**ESSO's comments to
submissions and answers
to ExA Questions
Submitted for Deadline 5**

**Application by ESSO Petroleum Company Ltd
for an Order Granting Development
Consent for the Southampton to London
Pipeline Project**

Application Reference EN070005

Applicant's comments on responses submitted for Deadline 5

Appendix QE.2.7.1: Works Plans - Addition of Queen Elizabeth Park Access (Sheet 35 & 106)

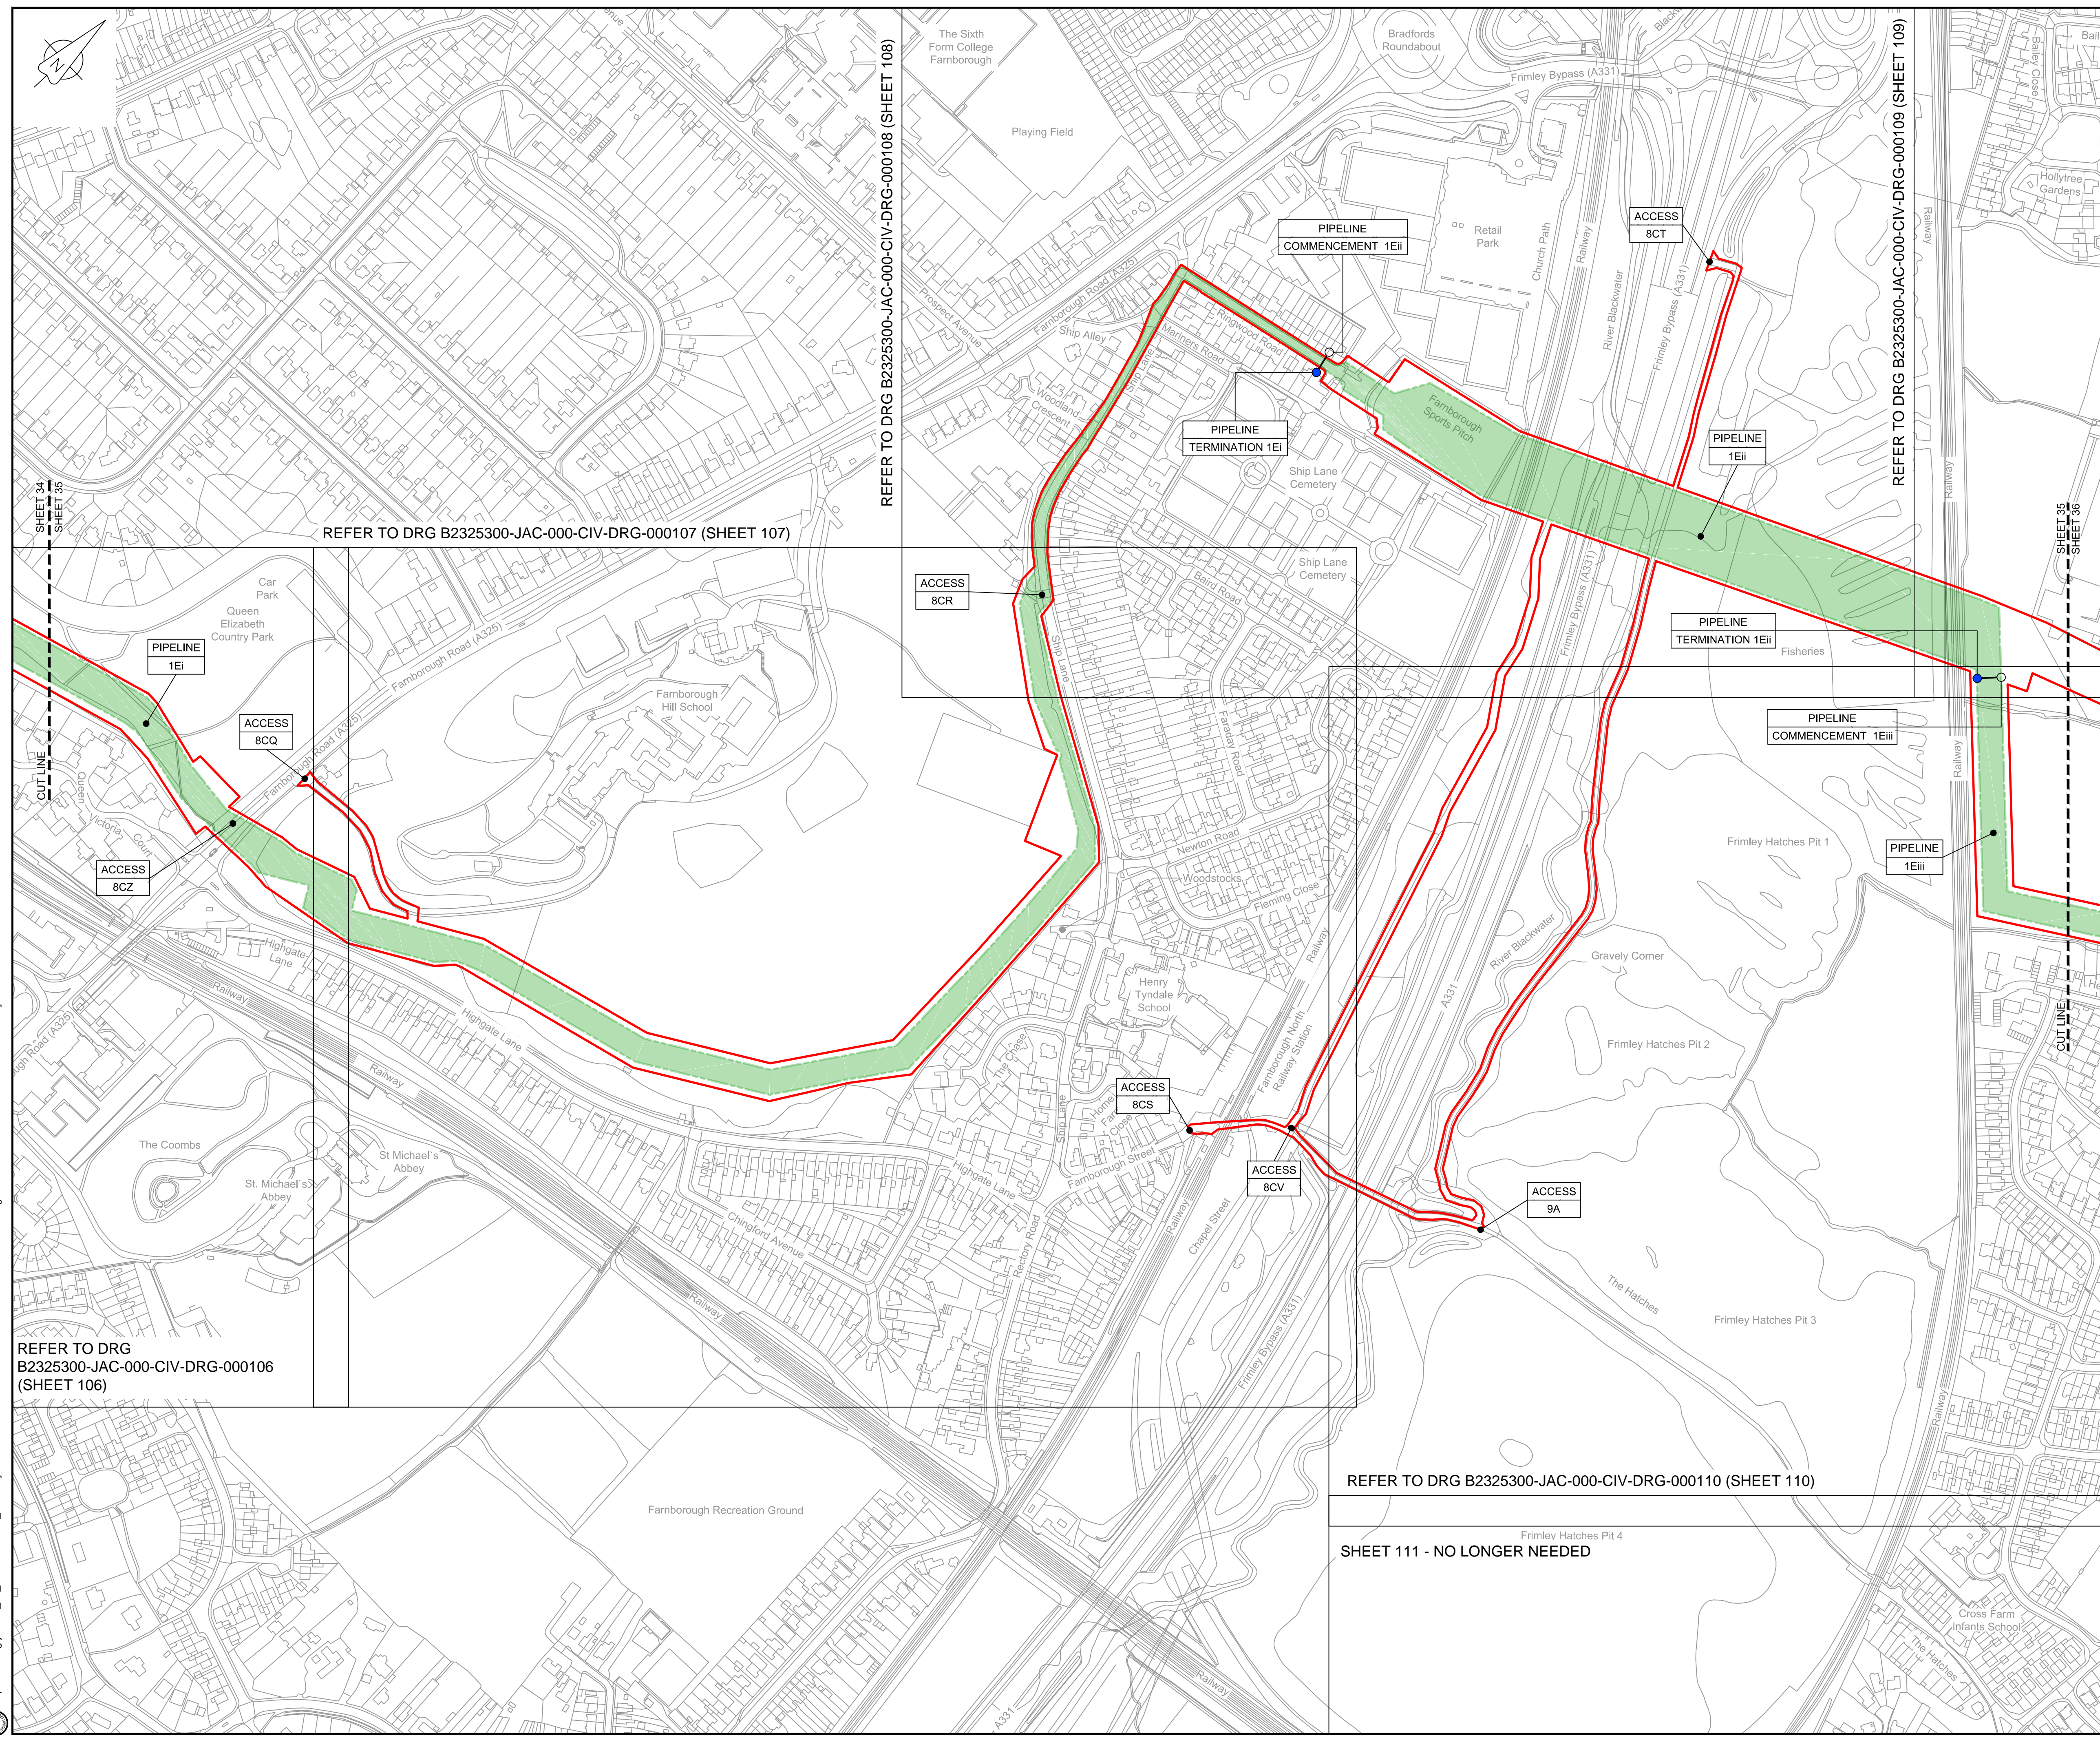
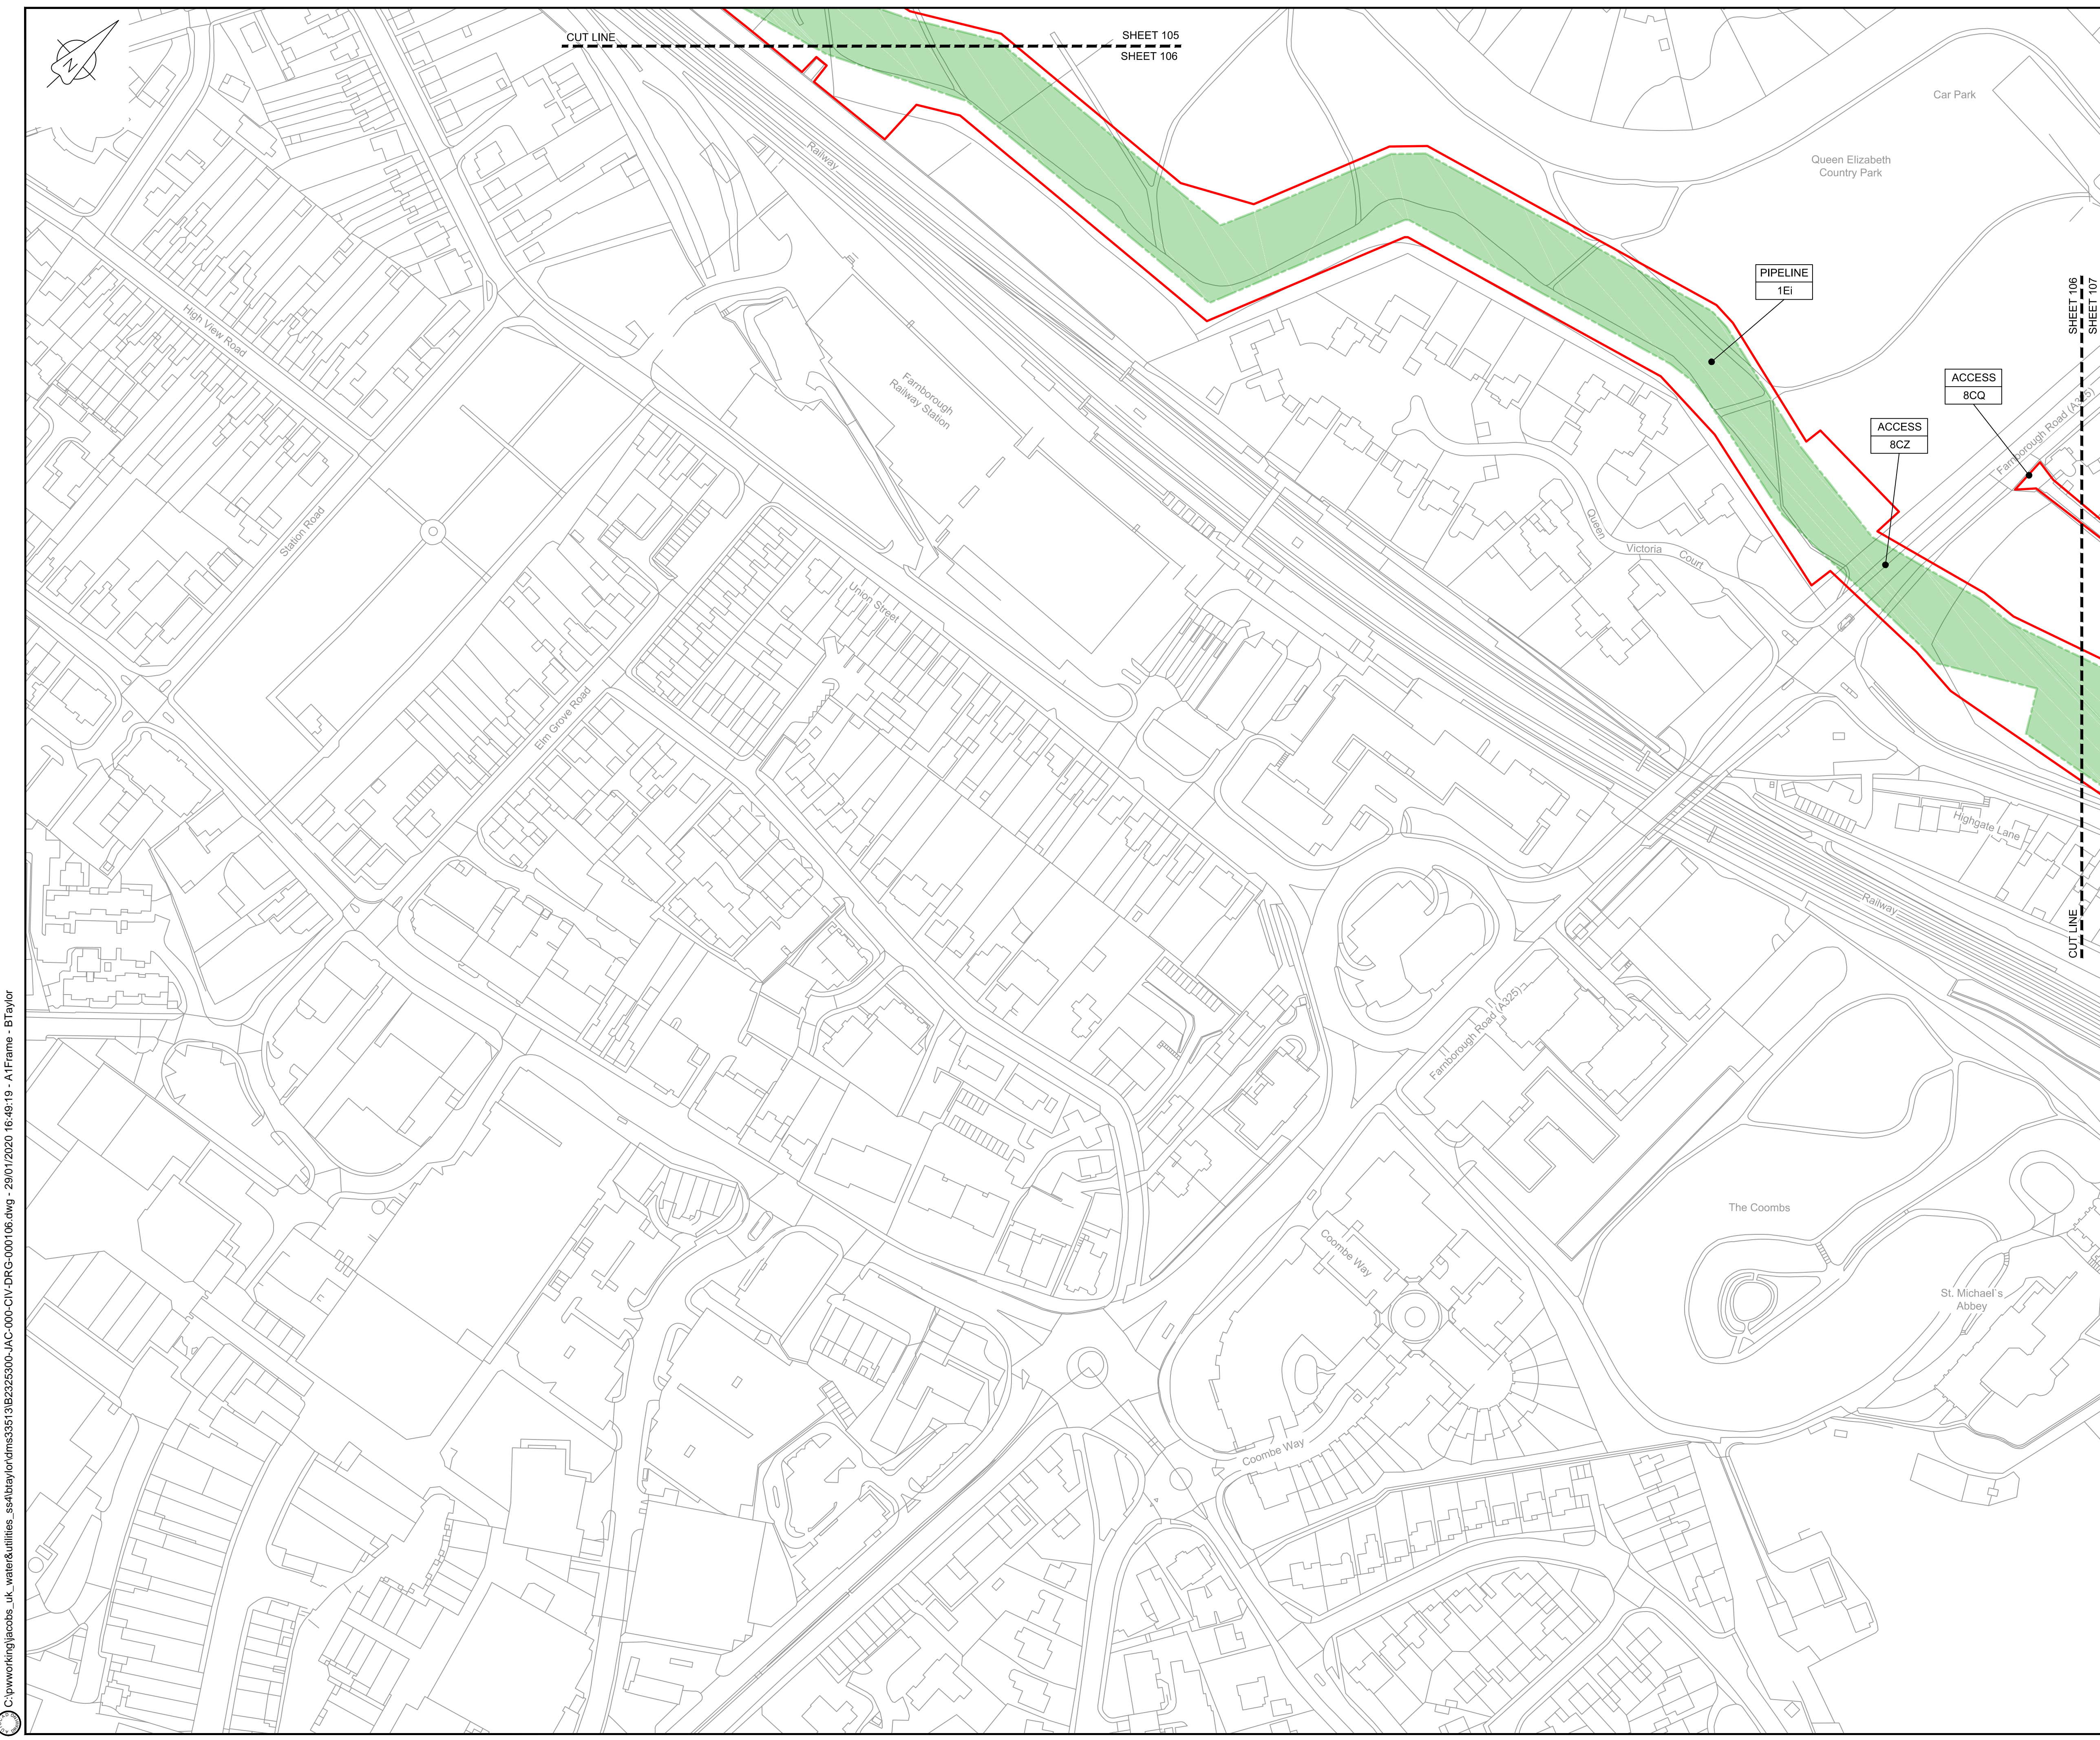
- 7.2.1 RBC wish to refer the ExA to the work undertaken by the Friends of Queen Elizabeth Park which show that the area identified for the auger pit is completely covered by RPZs. Damage to the root zones within this area would cause significant damage to many mature trees within the area and would be likely to lead to the fragmentation of the vegetated corridor along the A325 in the medium to long term. Even if no trees were removed, it is the impact on the root zones and the long term survival of the trees which is the council's greatest concern.

- 7.2.2 Within a meeting held on 26th February 2020, the applicant provided further verbal information as to how the compound was to be constructed and the machinery was to be accommodated in this area. RBC was informed that a ramp would be constructed with hard surfacing placed over the top of the ramp to enable access. This was new information and not included anywhere within the application documents. The council is extremely concerned regarding these plans as we feel that this is paramount to land rising and is likely to change the sensitive hydrology of the woodland for the duration of the works and possibly in the longer term. RBC is also concerned that the weight of this structure, coupled with the facilities and machinery planned to be accommodated within the pit and compound, would be likely to lead to severe compaction of any roots under the structure, causing long term damage to the root systems of a number of significant boundary trees.
